WELWYN HATFIELD ACCESS GROUP
 the common room
 ground floor
 ley house
 long ley
 welwyn garden city
 hertfordshire al7 2ex

7 August 2014

re: Planning Applications Received by Welwyn Hatfield Council

Application No.	Description and Location	Applicant/Agent
S6/2014/1443/MA	Erection of new public house and associated works. Land off Comet Way Hatfield AL10 0XY	Mr N Bunt Absolute Interiors Riverside View Newham Road Truro TR1 2SU

Drawing Title:
Exterior Shelter

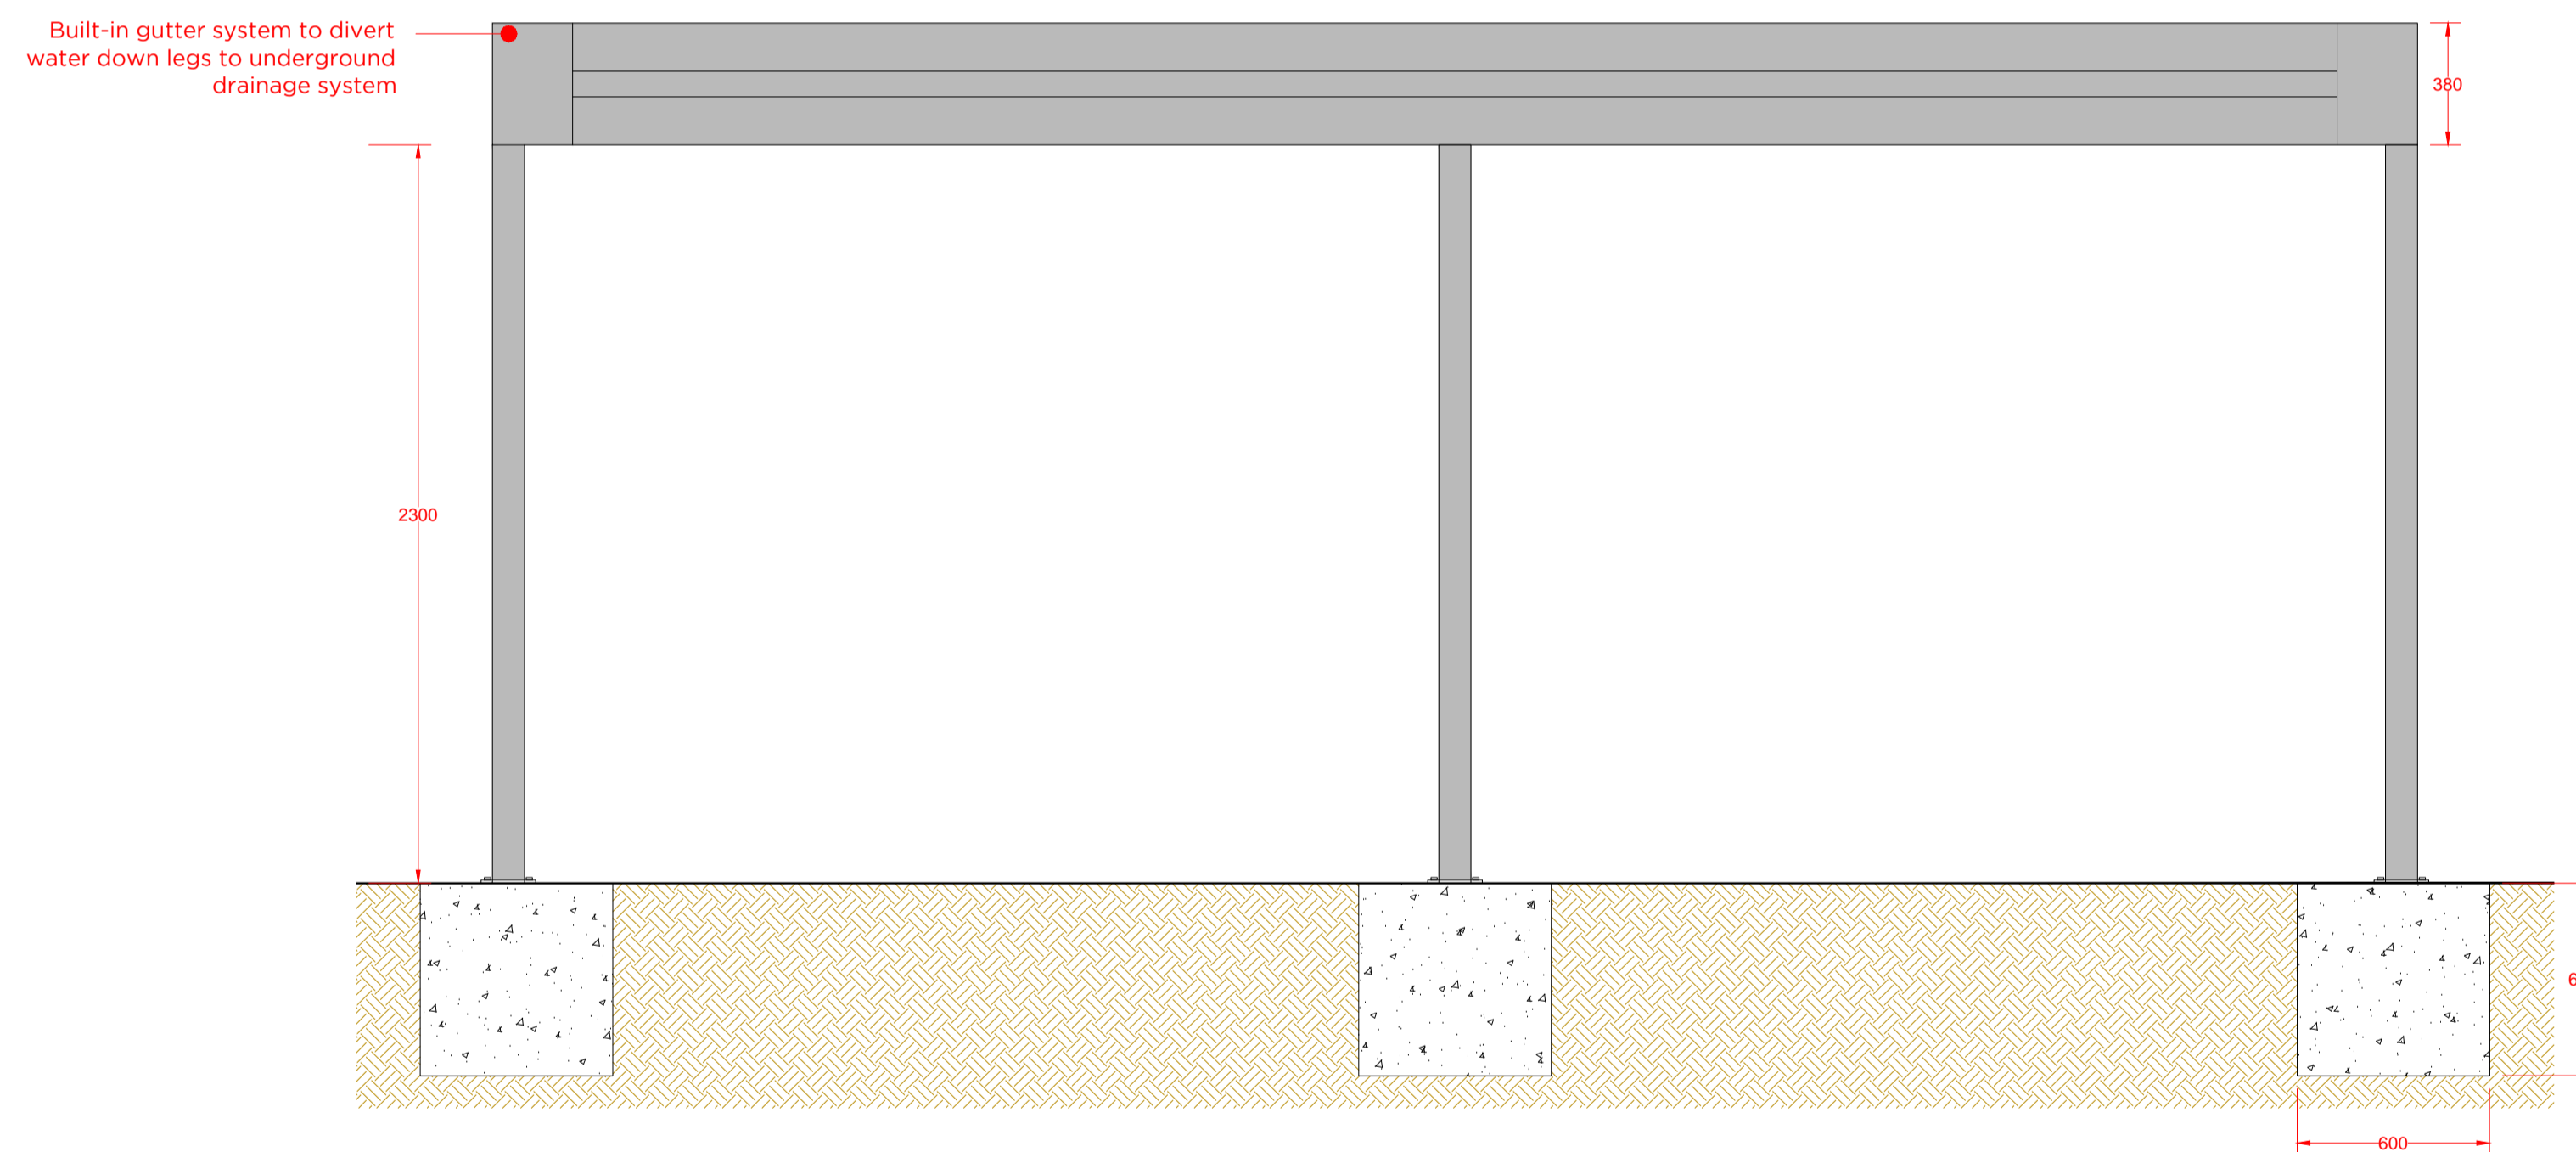
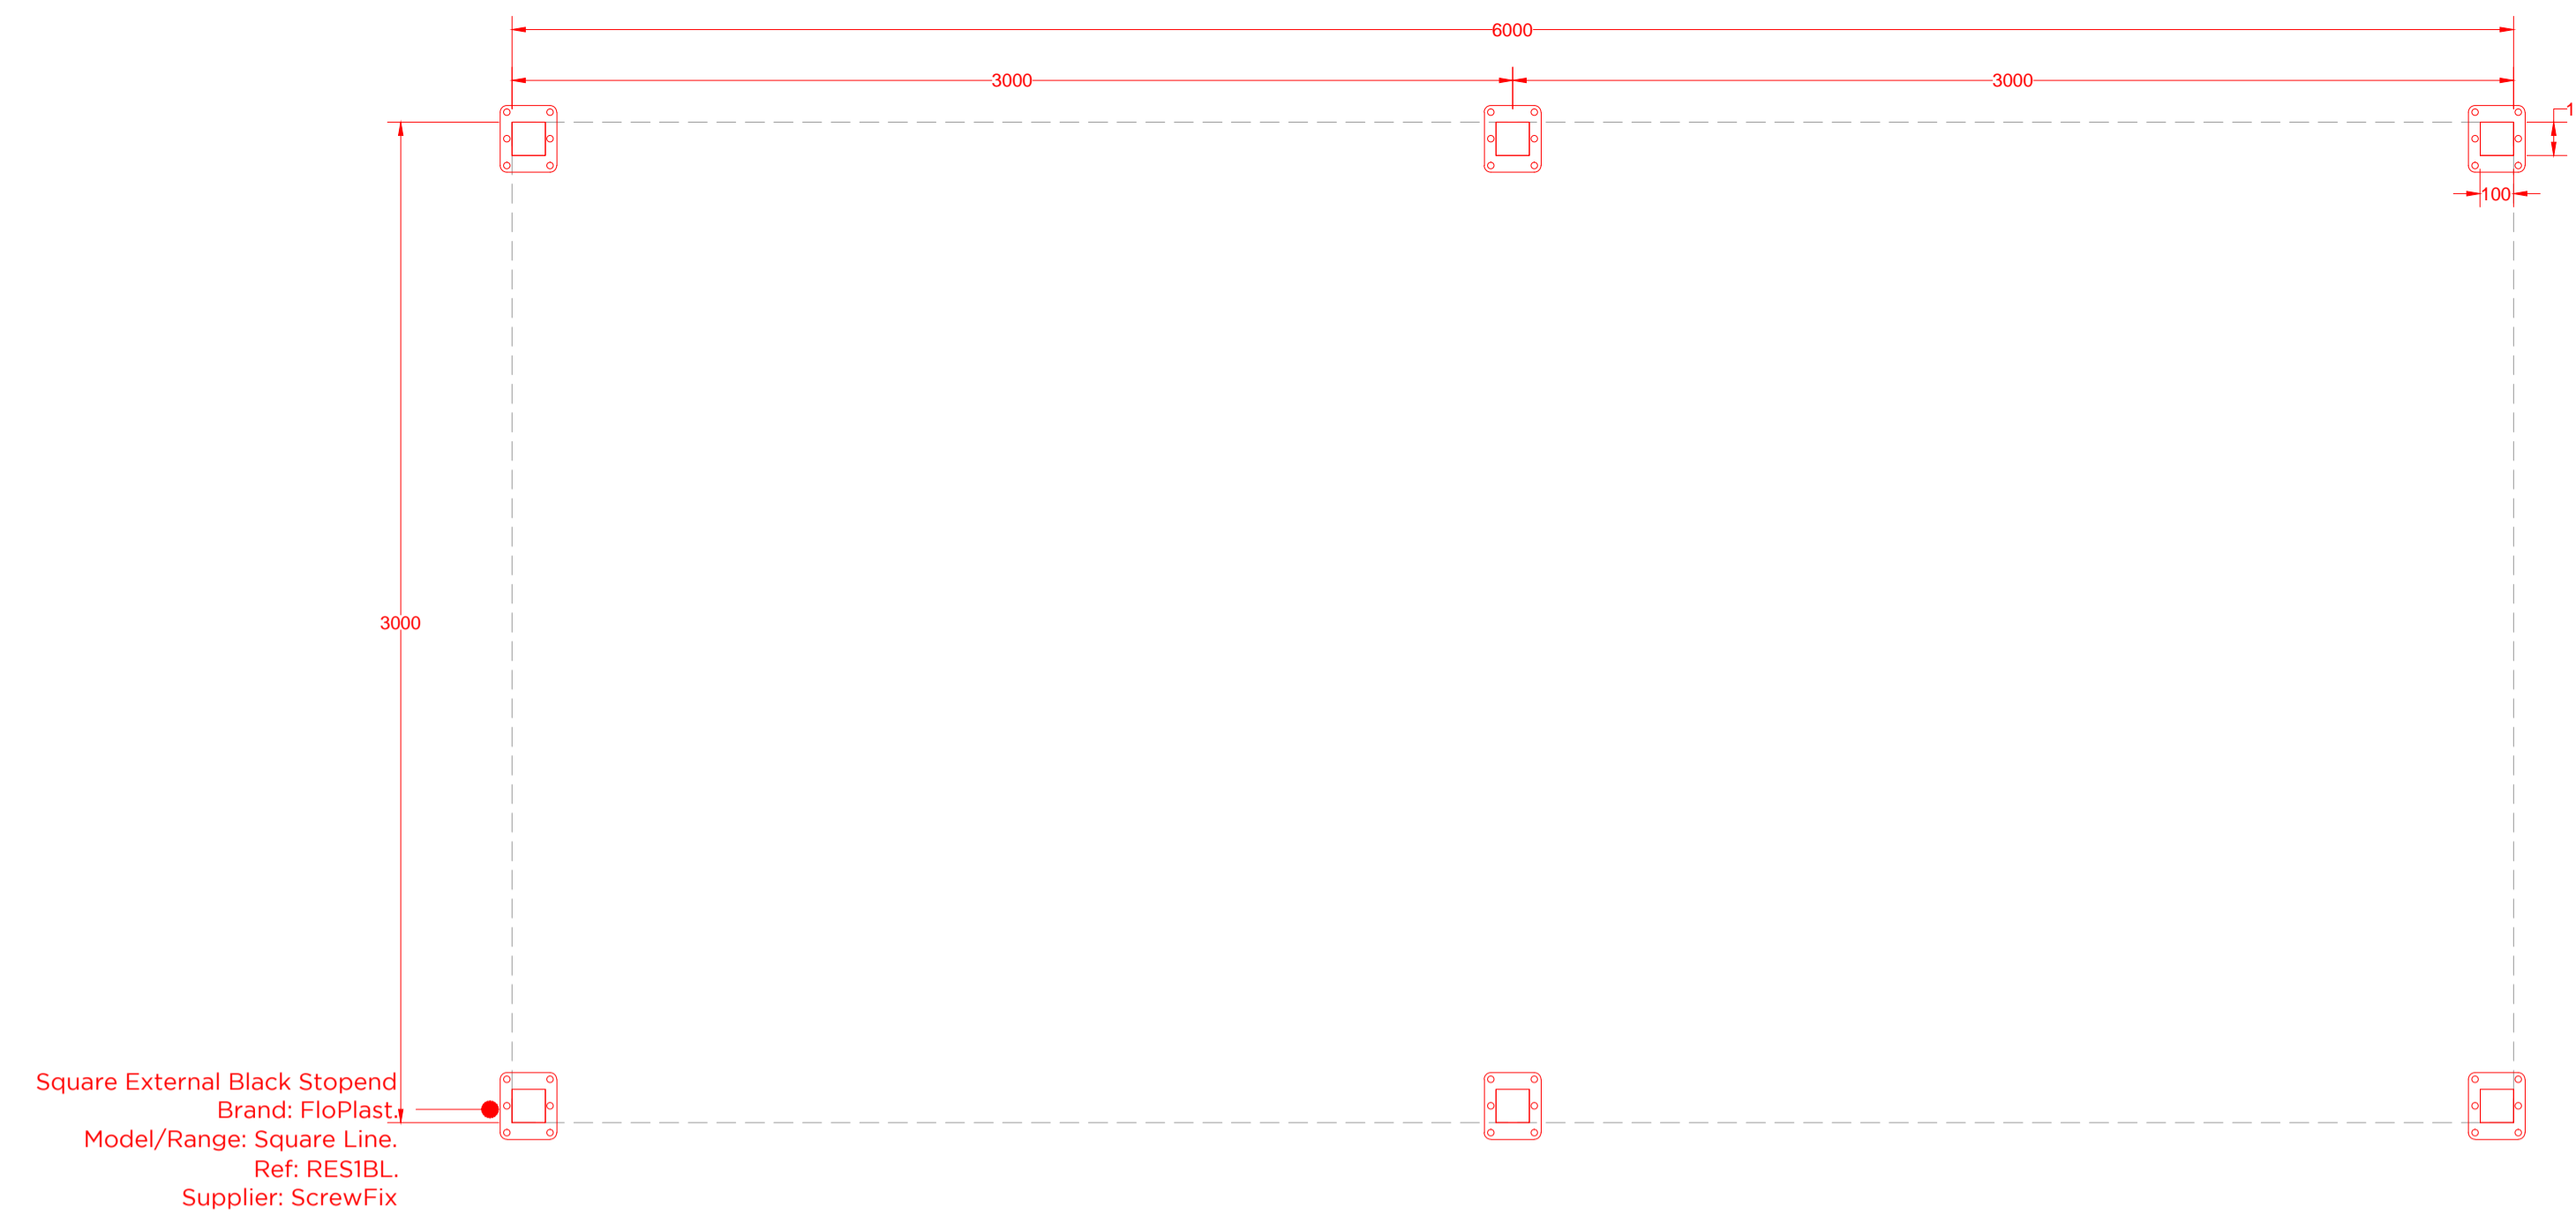
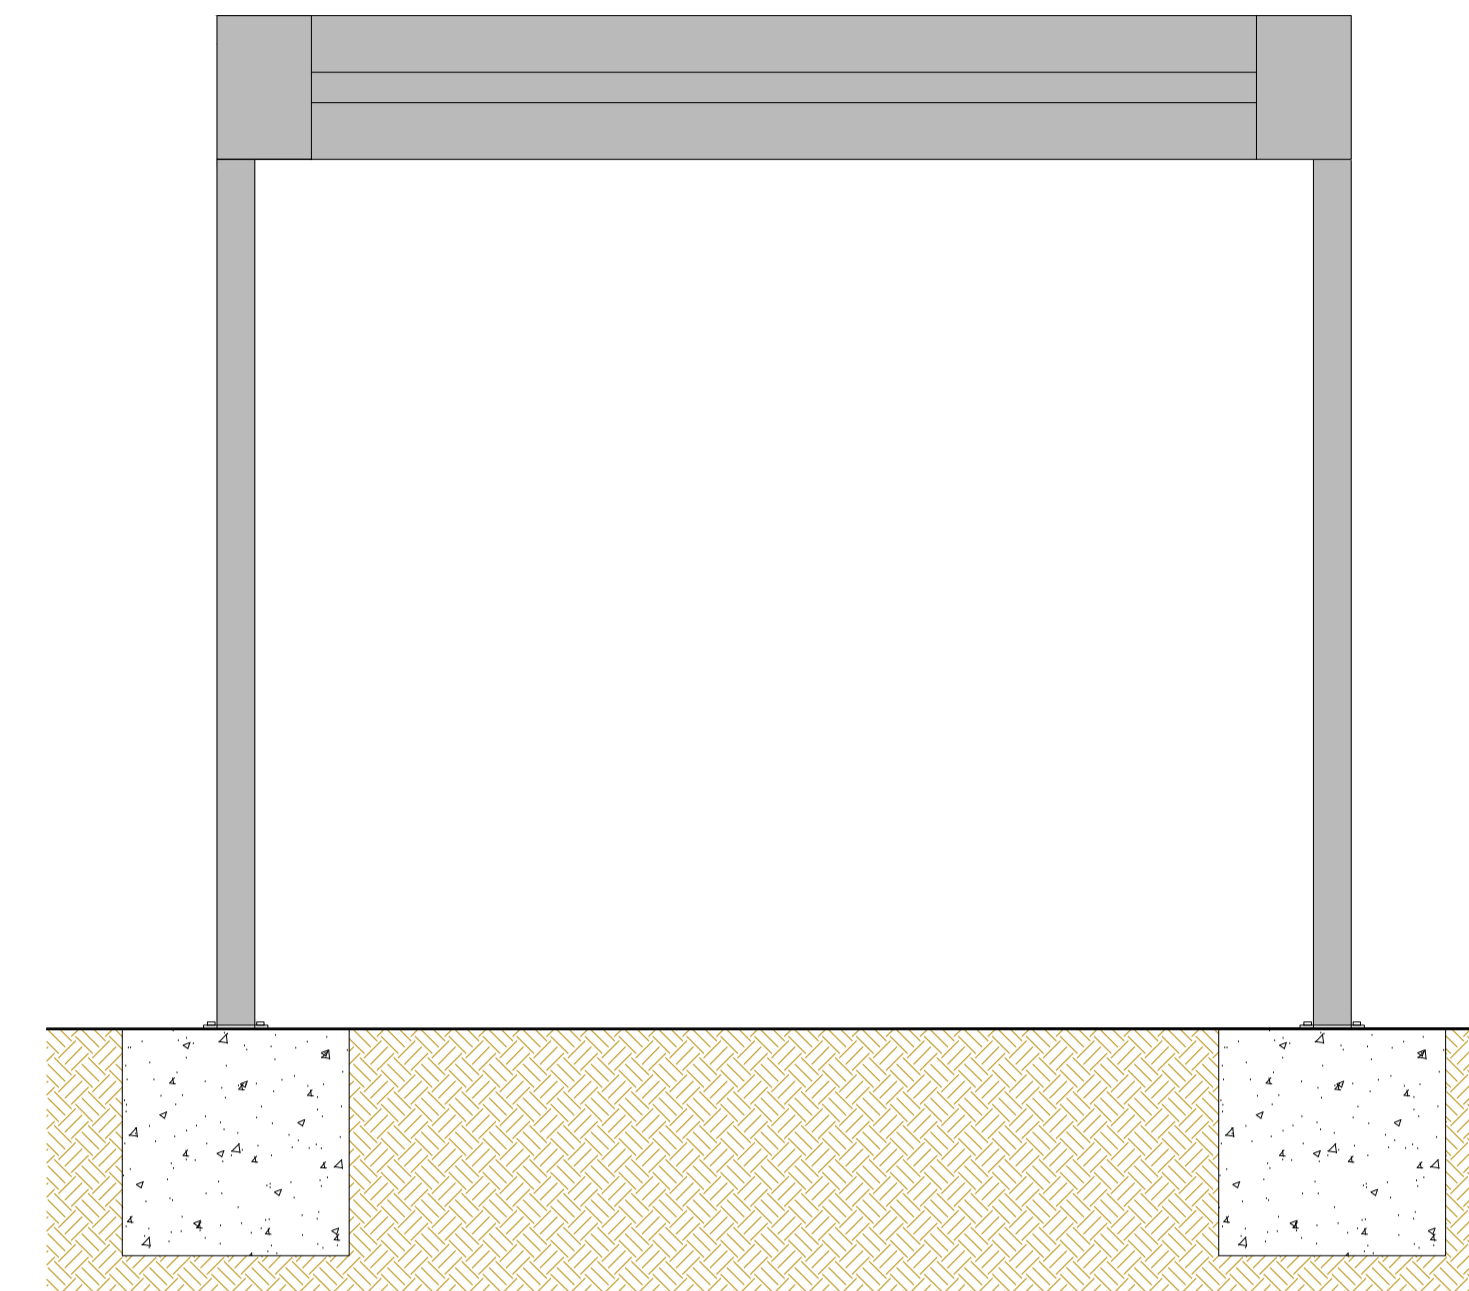
Could you kindly confirm the approaches and shelters will be wheelchair accessible?

Drawing No. & Revision:
7127 - 200-TPL

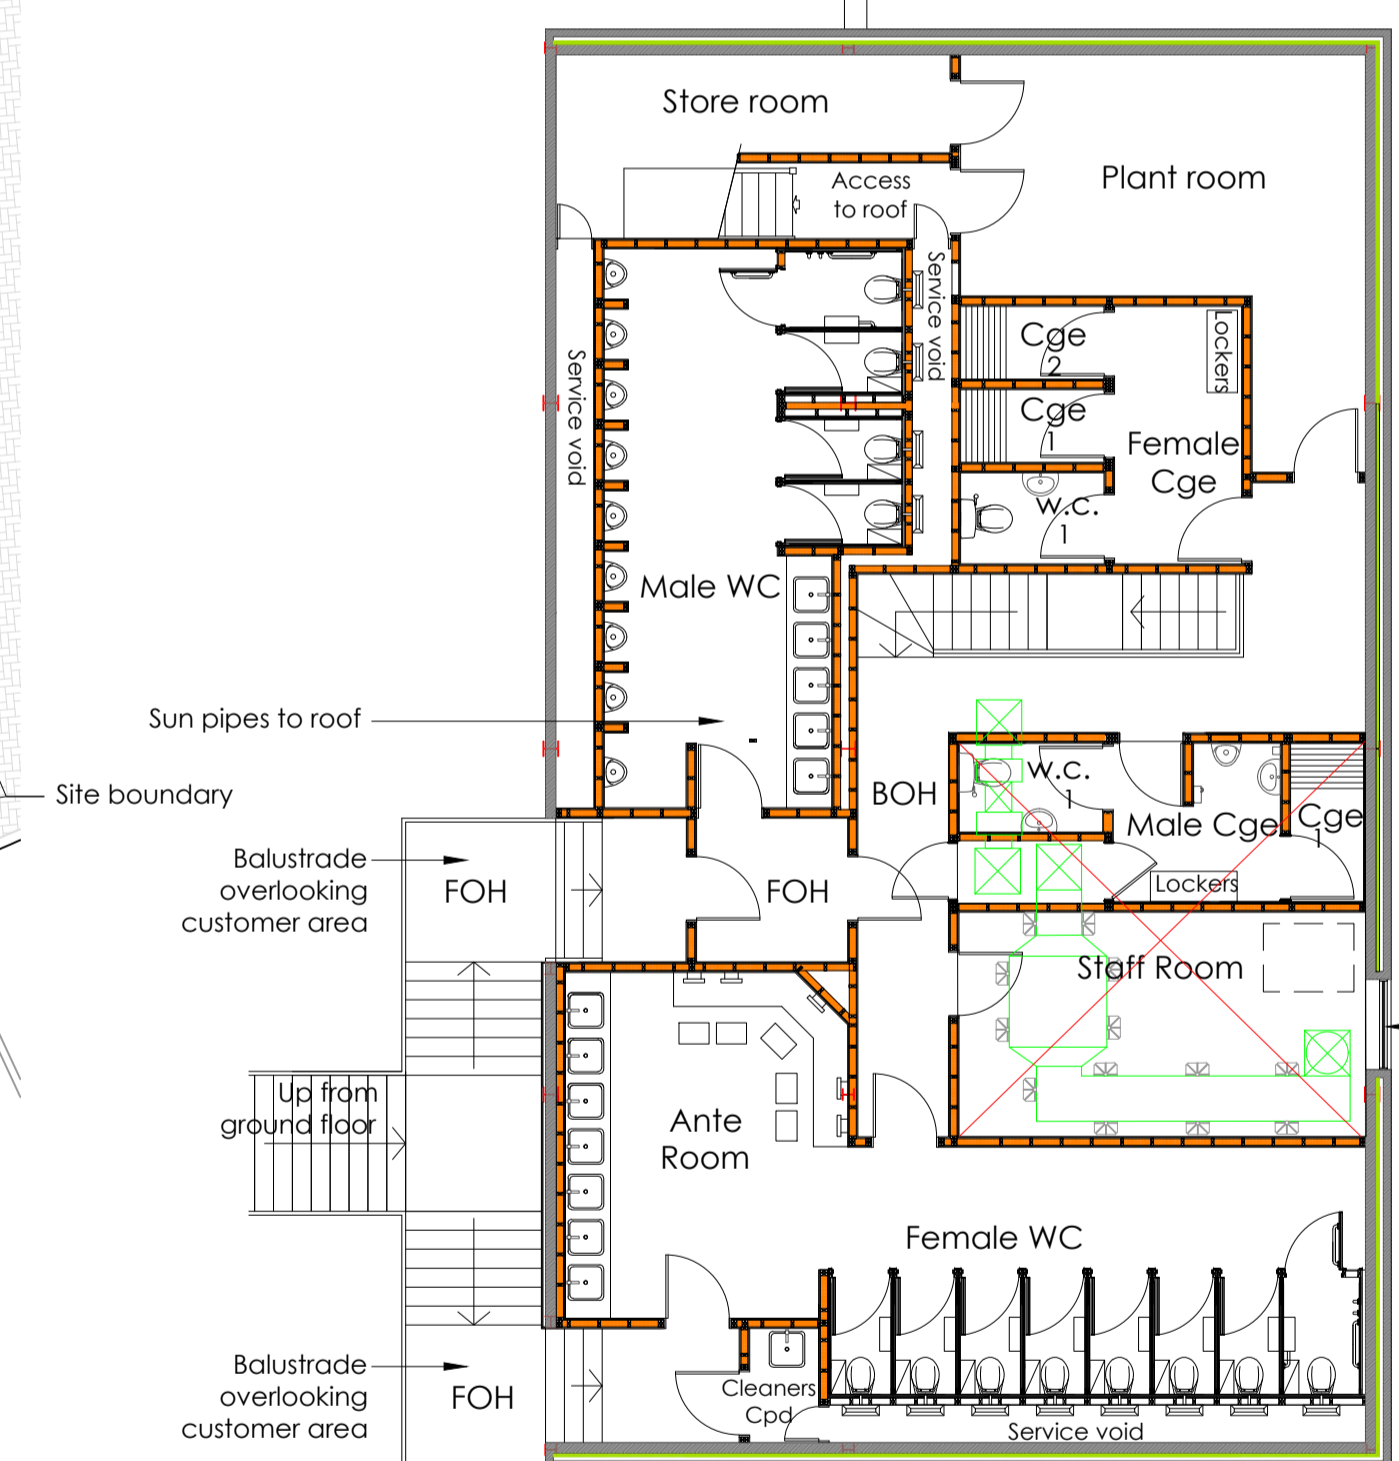
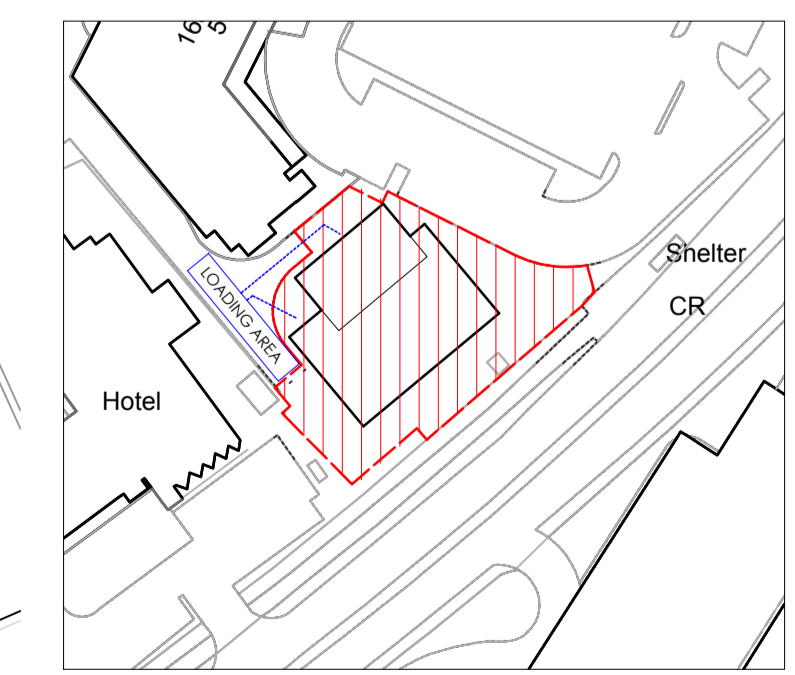
We note the provision of a disabled toilet on the ground floor with all other toilets on the first floor. We also note the disabled toilet is located at the farthest point from the entrance lobby. This same drawing highlights the location of two smoking shelters and the beer garden.

With the disabled toilet being located on the ground floor and all other toilets on the first floor we believe, from our experiences, that the ground floor disabled toilet will be routinely used by able bodied people. Is it your intention to minimise this factor by installing a Radar key system on the disabled toilet door?
